From: Thomas Callaway
Sent: 27 September 2013 16:47
To: Planning.Responses
Subject: RE: Planning Consultation on: M/65/13/

Engineers comments in respect to surface water drainage:

APPLICATION M/65/13/

Site Address: Summer Cottage 14 West Drive Elmer PO22 7TS

SHEET. 8. PROPOSALS

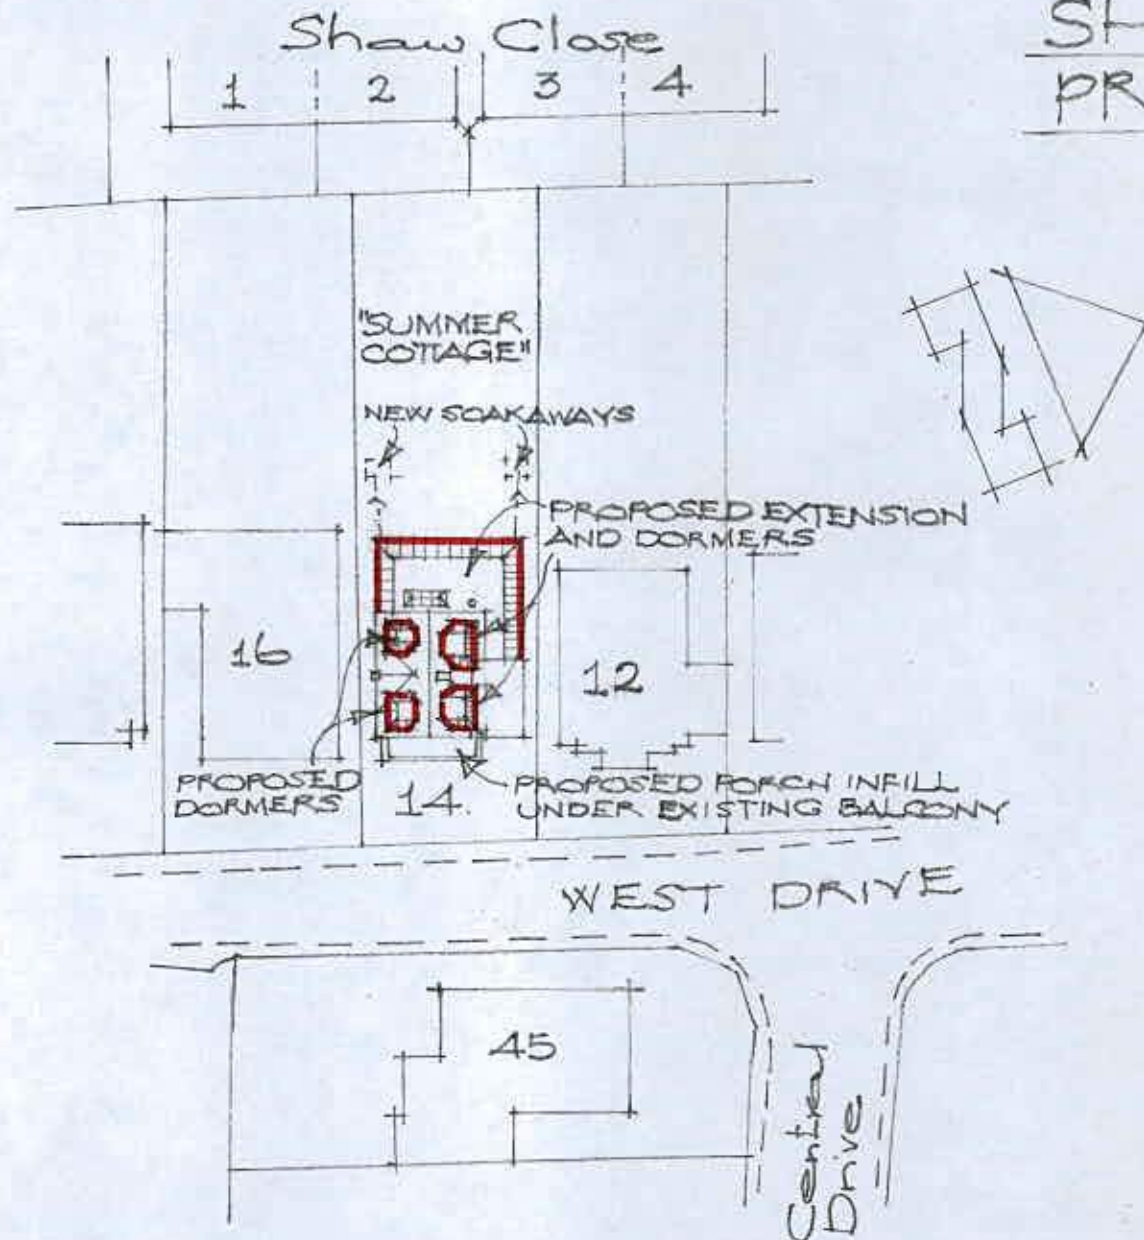
The property is within the Lidsey Treatment Works catchment area, therefore we have been consulted on this application for extension and alteration work to the property. The applicant states that surface water will be discharged to mains drainage, which is generally unacceptable, but especially so in this area. A SuDS system (Sustainable Drainage System) must be investigated for surface water disposal, ie. soakage structures.

Infiltration rates for soakage structures are to be based on percolation tests undertaken in the winter period and at the location and depth of the proposed structures. The percolation tests and design must be carried out in accordance with BRE 365, CIRIA R156 or a similar approved method and cater for the 1 in 10 year storm between the invert of the entry pipe to the soakaway, and the base of the structure. It must also have provision to ensure that there is capacity in the system to contain below ground level the 1 in 100 year event plus 30% on stored volumes, as an allowance for climate change. Adequate freeboard must be provided between the base of the soakaway structure and the highest recorded annual groundwater level identified in that location.

Any SuDS or soakaway design must include adequate groundwater monitoring data to determine the highest winter groundwater table in support of the design. The applicant is advised to discuss the extent of groundwater monitoring with the Council's Engineers. Supplementary guidance notes are also enclosed for information.

Please apply standard conditions ENGD2A.
